JKH:AM  
Environment & Development Dept.

3 October 2013

**(SSD-5579) CENTENNIAL WESTERN COAL SERVICES PROJECT – LITHGOW COUNCIL SUBMISSION**

Figure 4 Noise Sensitive Receptors Blackmans Flat Detailed

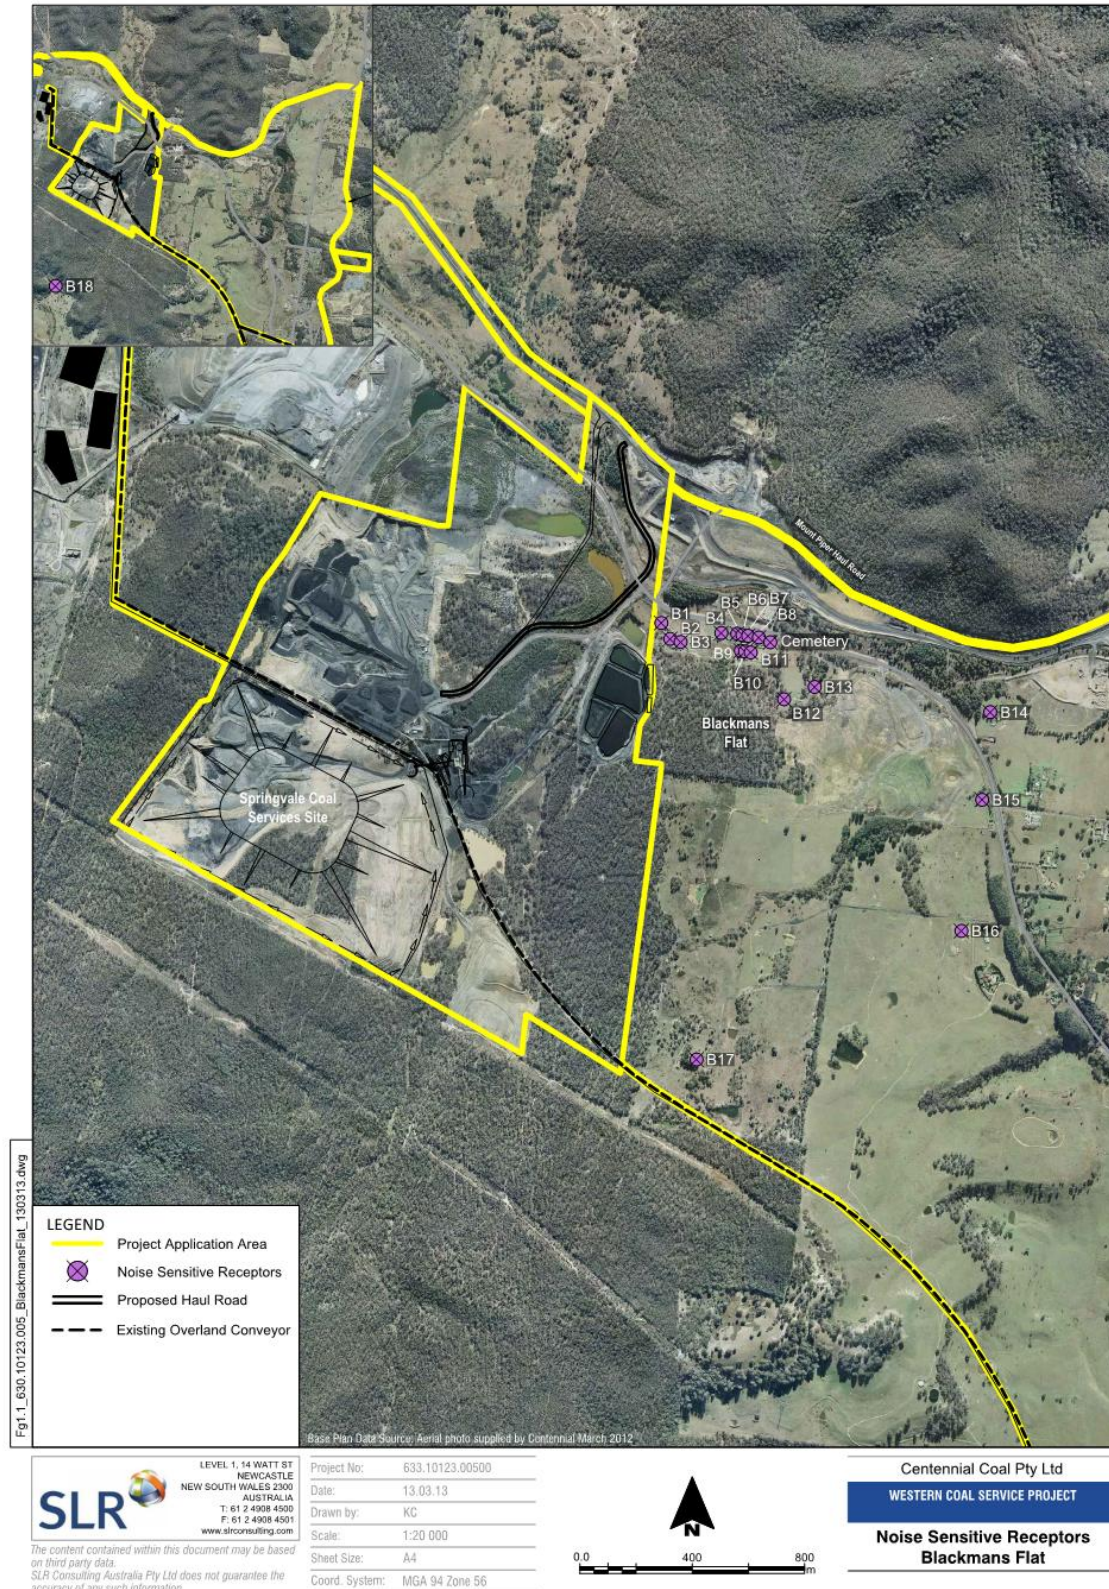
In Table 17 (EIS p102) 11 out of the 16 receptors for Scenario 2 at Blackmans Flat will not meet the noise criteria for the project during evening and night periods. Only one negotiated agreement will be arranged for the worst case receptor B17, with no other negotiations stated. It is noted that out of these 11 receptors the following averages are evident from modeling:

- on a windy evening the average noise level is 4dBA above the project specific criteria
- on a calm night the average noise level is 2.4dBA above the project specific criteria
- on a windy night the average noise level is 1.2dBA above the project specific criteria
- on a night with inversion the average noise level is 4.2dBA above the project specific criteria

Further in Table 29 (EIS p.108) that the predicted maximum (worst case scenario) noise levels (L<sub>Amax</sub> dBA) will not meet the 'Sleep Disturbance Noise Goal' at 13 of the receptors in Blackmans Flat. These levels are on average 12.7dBA above the criteria set, even if the applied 10dBA is taken into consideration (for difference of outdoor noise level to indoor noise level with all openings closed), the average is still 2.7dBA above the criteria. Table 32 (EIS p.109) also states exceedences for sleep disturbance criteria at Wolgan Road receptors on an average of 7dBA.

Council considers that these noise levels, although worst case scenario, do not meet the set criteria for the project and require mitigation. Additional noise mitigation measures such as limiting movements during evening and night could be implemented to reduce issues of noise, especially on Blackmans Flat. Additionally, the use of acquisition agreements could be implemented for additional receptors to give residents an option, if ongoing issue of noise at Blackmans Flat becomes evident once the development is operational.
